1 December 2022

610.30799-L02-v1.0-20221201.docx

TOGA Central Block C Response to Waste Management Issues Raised by City of Sydney

Figure 4 Waste storage rooms

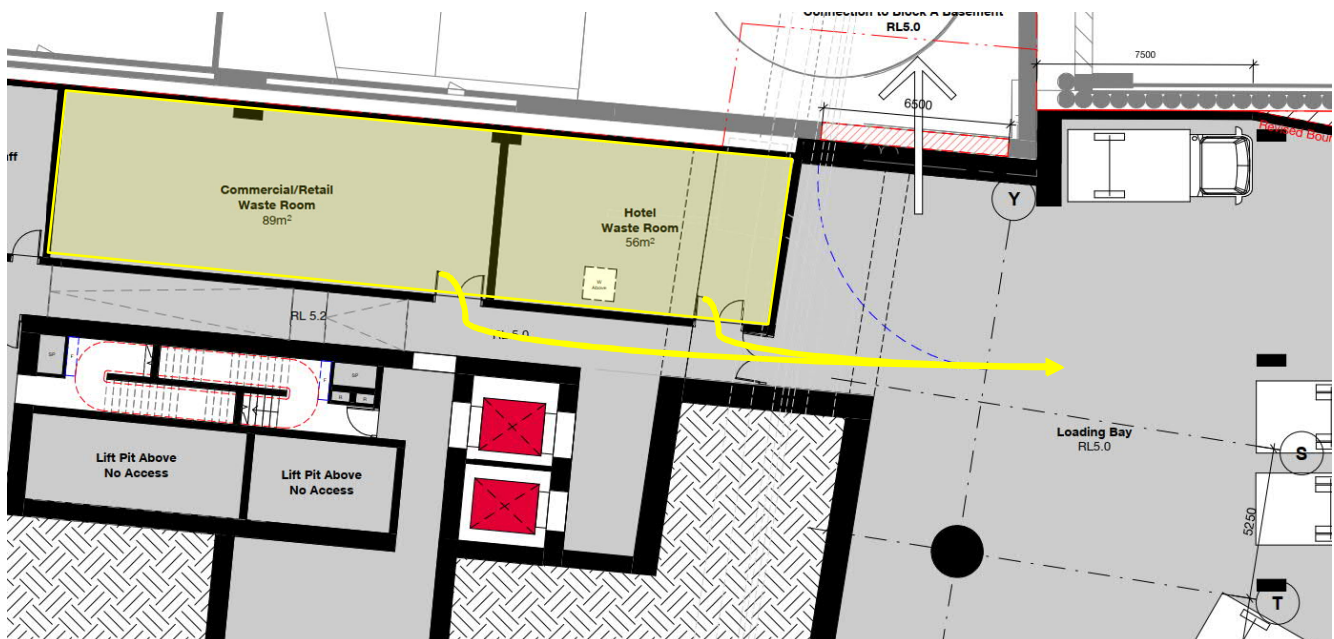
The Architectural plans are to clearly show the proposed layout of bins within storage areas with the bins correctly scaled, distinguishing between sizes (eg 240L, 660L, 1100L).

Additional design considerations should be shown on the plans in relation to:

- Ensuring adequate door width for the size of the bins; and

Identify space dedicated for storing bulky waste and problem waste for recycling (see Guidelines for Waste Management in New Developments 2018 for minimum requirements).

The most recent plans, BSMART-AR-DAD-10B03000[2] General Arrangement Plan Basement Level 03, show separate waste storage areas for retail, commercial and hotel waste. The drawings also show space allocations and a possible layout for the proposed number of bins of different capacities as well as balers for cardboard and plastics, food waste dehydrators, crushed glass bins, cooking oil, cardboard and soft plastics storage. See Figure 1 below.

The drawings also show that the doorway entrances to each waste room have a width of about 1.5 m, which is wide enough for any of the proposed bins to pass through.

The most recent plans also show storage space for bulky and problem waste, see Figure 1 above, which have been calculated using the formula specified in the City's Guidelines.
